**Your Ref** 23/01151/APP

**PROPOSED NON-MATERIAL AMENDMENT TO PLANNING PERMISSION REF. 23/01151/APP AT HMP SPRINGHILL, EDGOTT, AYLESBURY**

Proposed changes to the approved plans are:

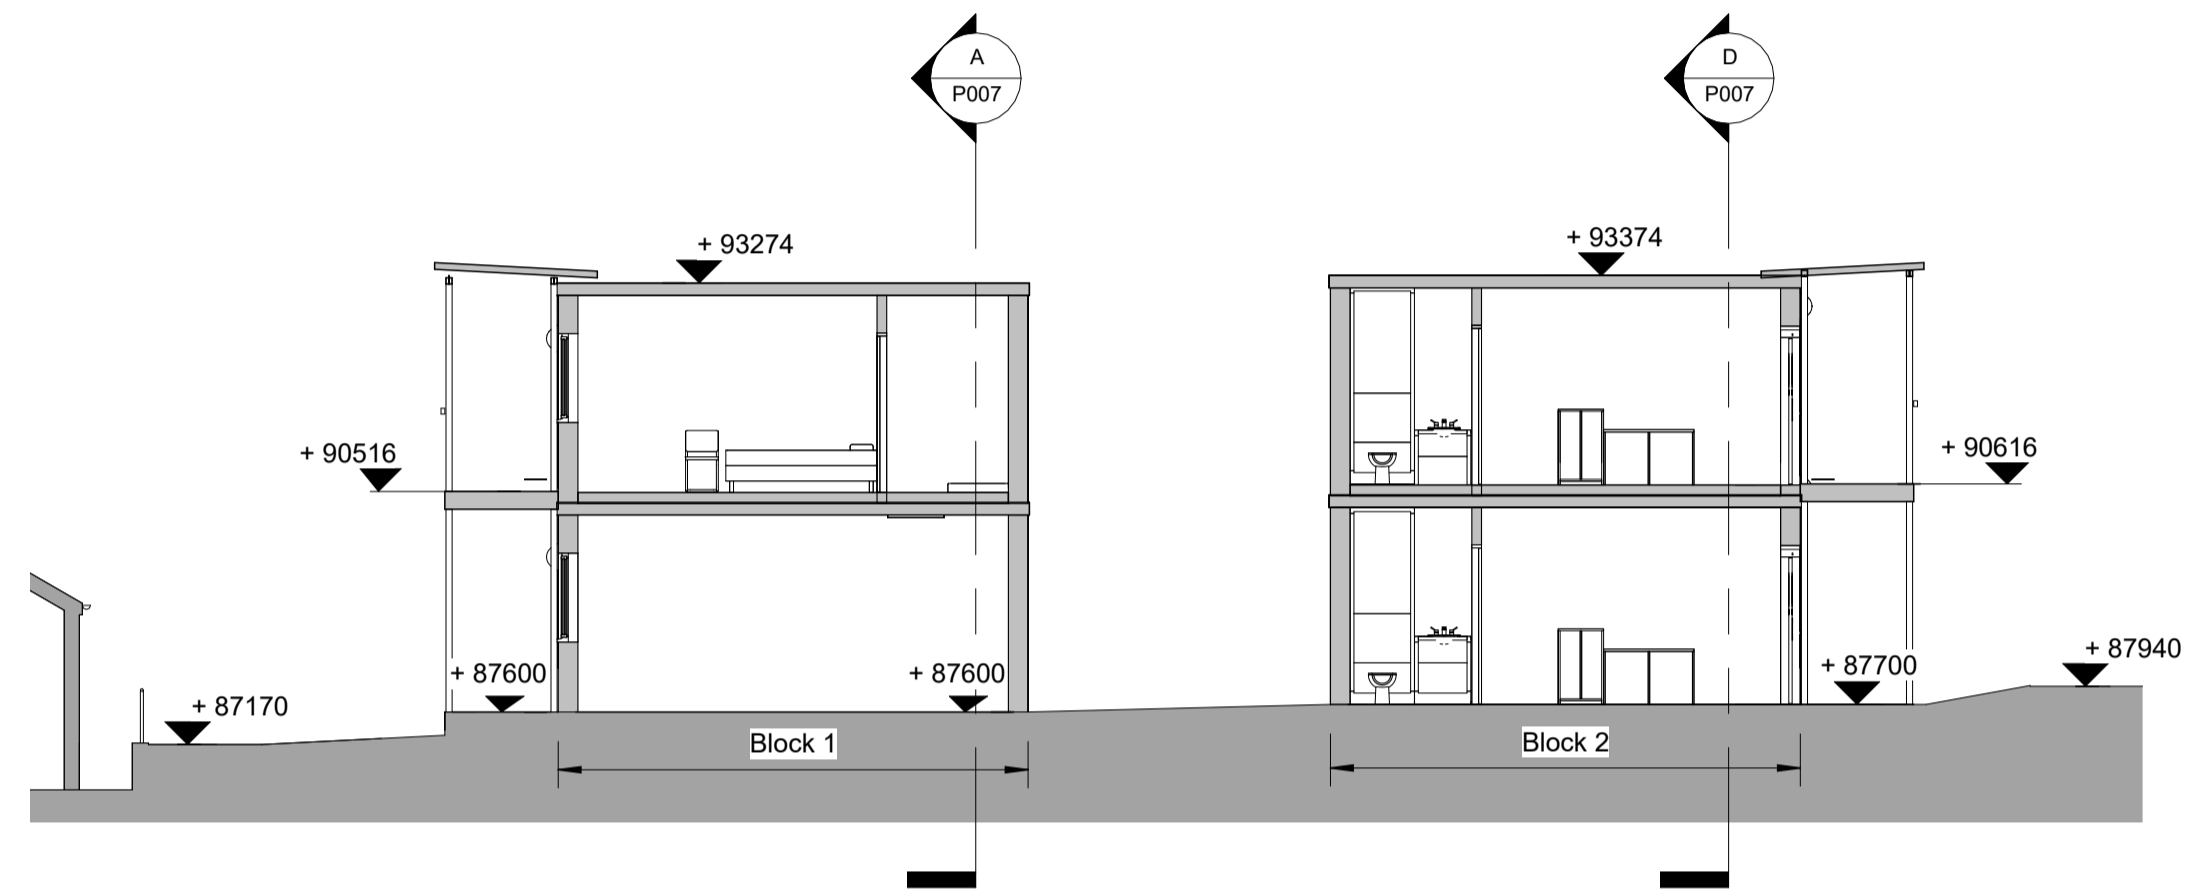
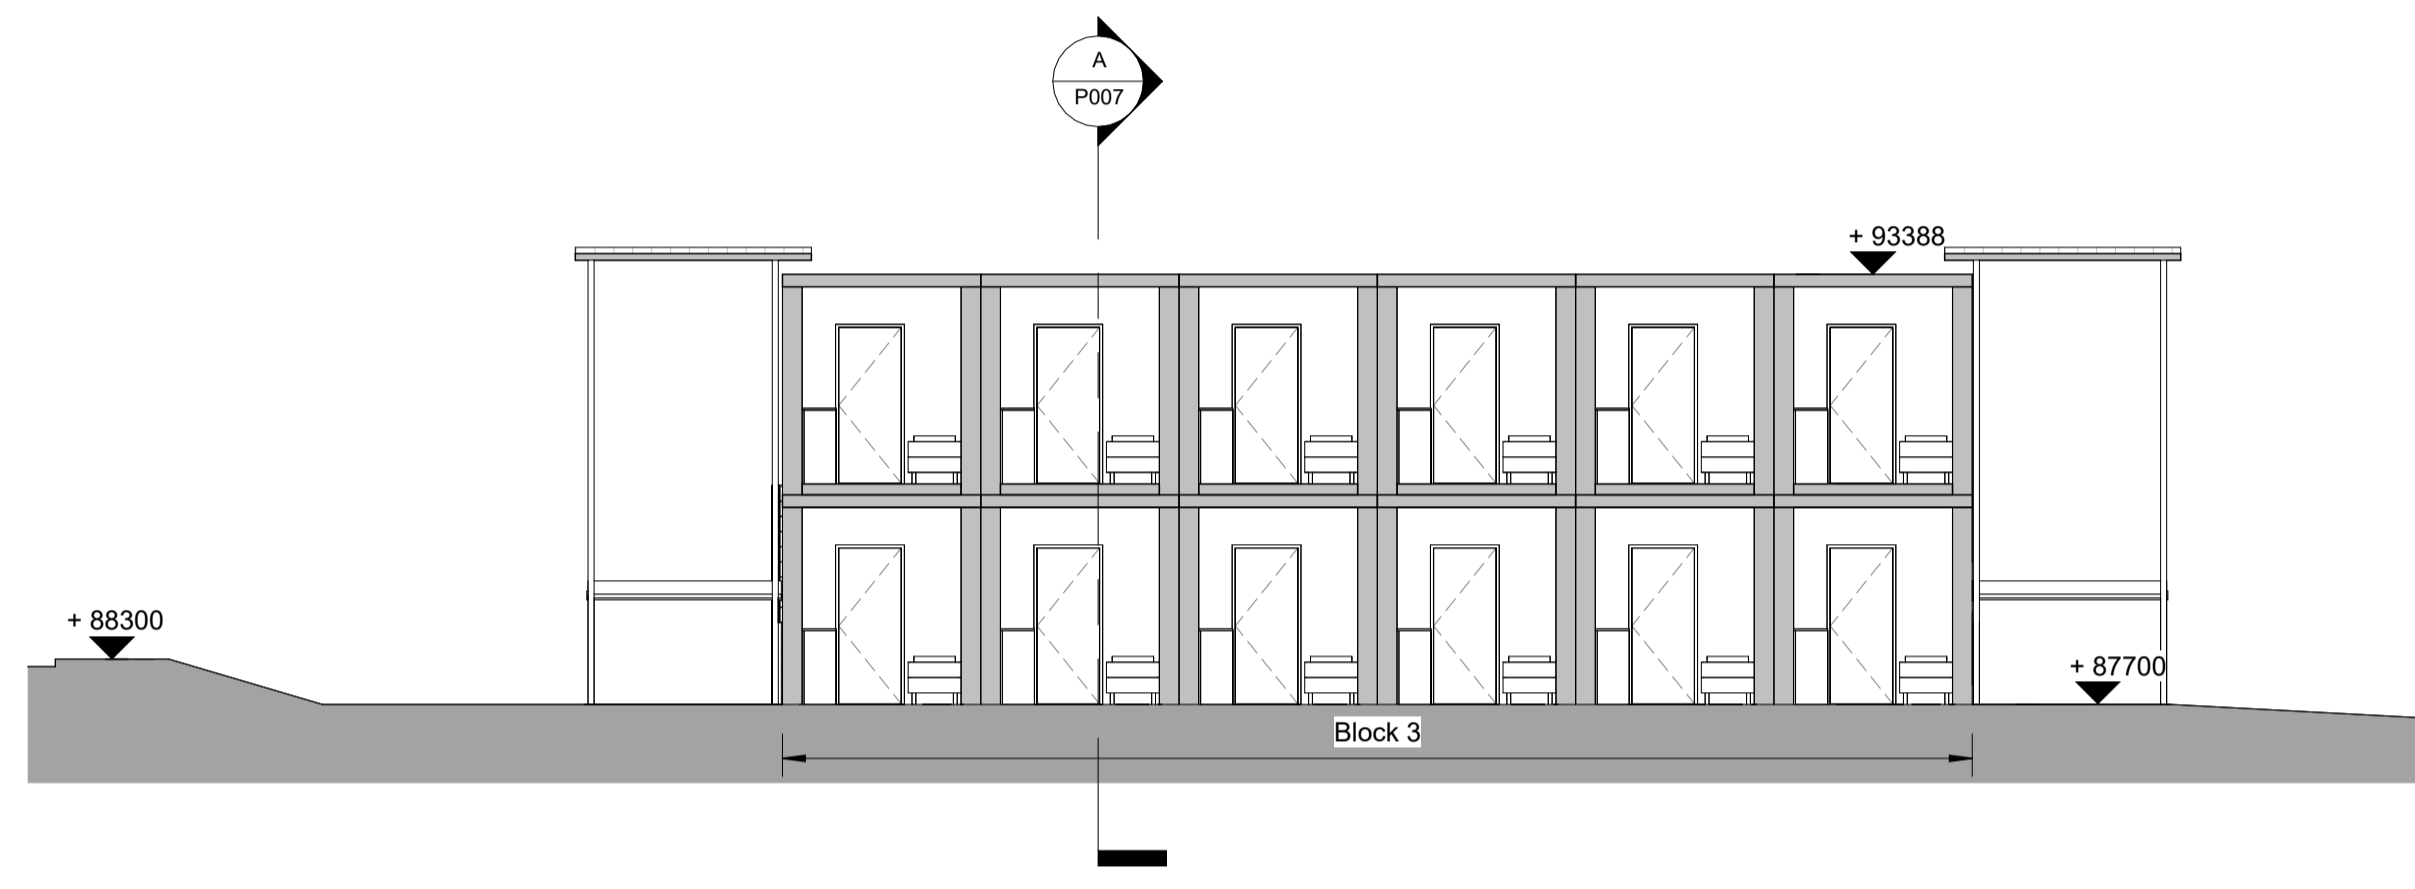
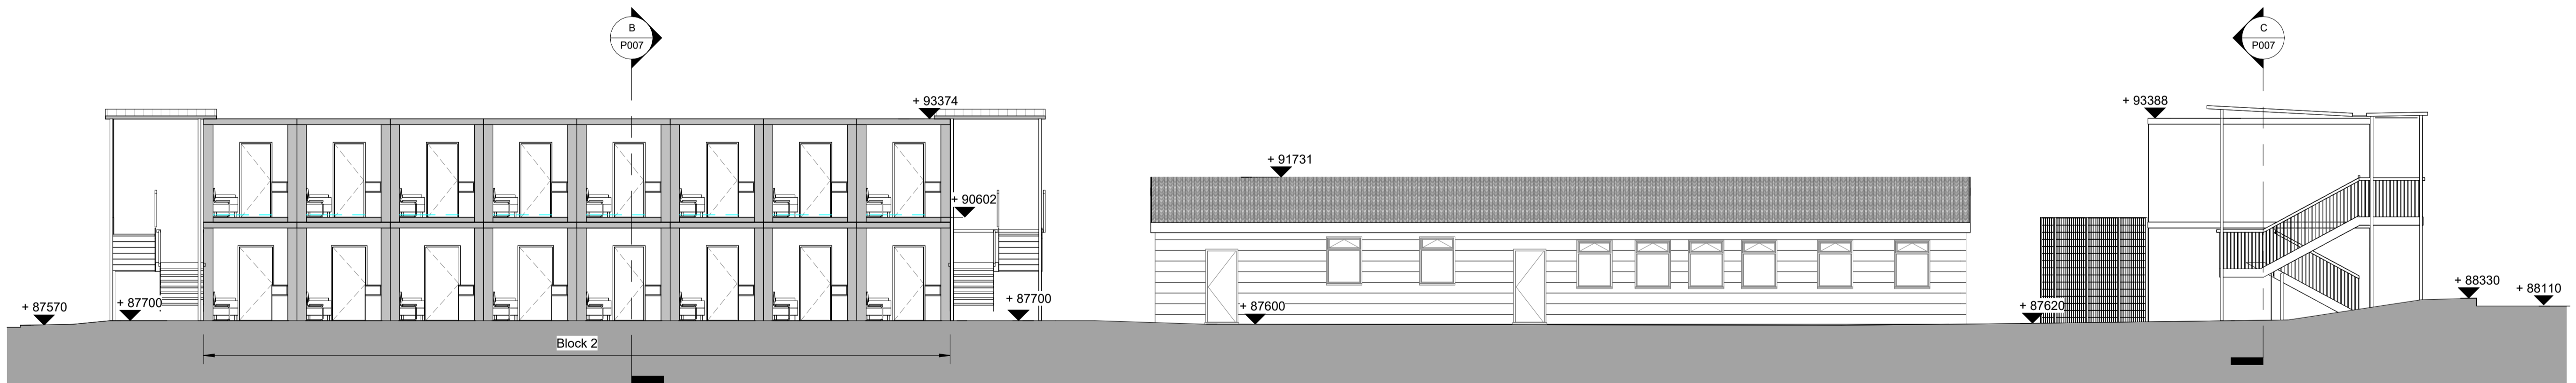
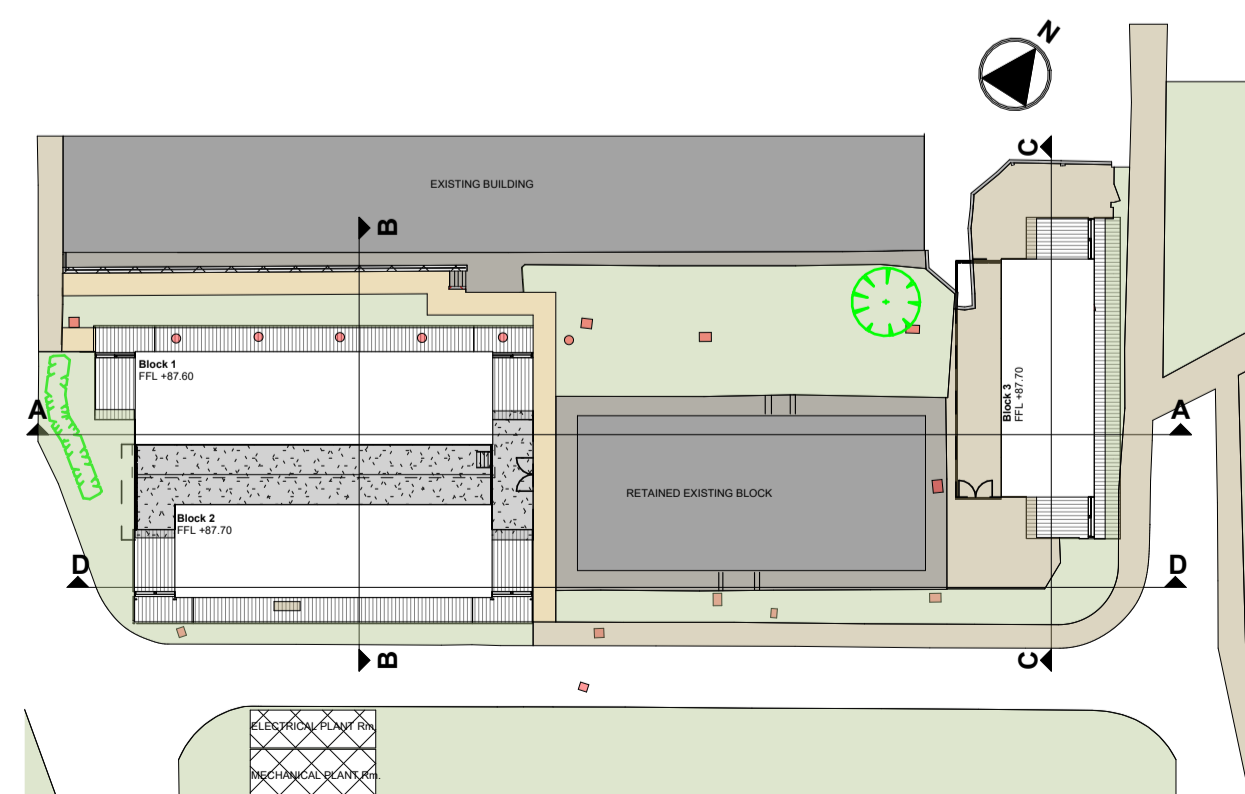
The finished floor levels of blocks 1 & 2 have been raised meaning the ridge is higher in comparison to the original. A step in the level has been removed as a result.

Block 3 has been moved to the east by 2 meters.
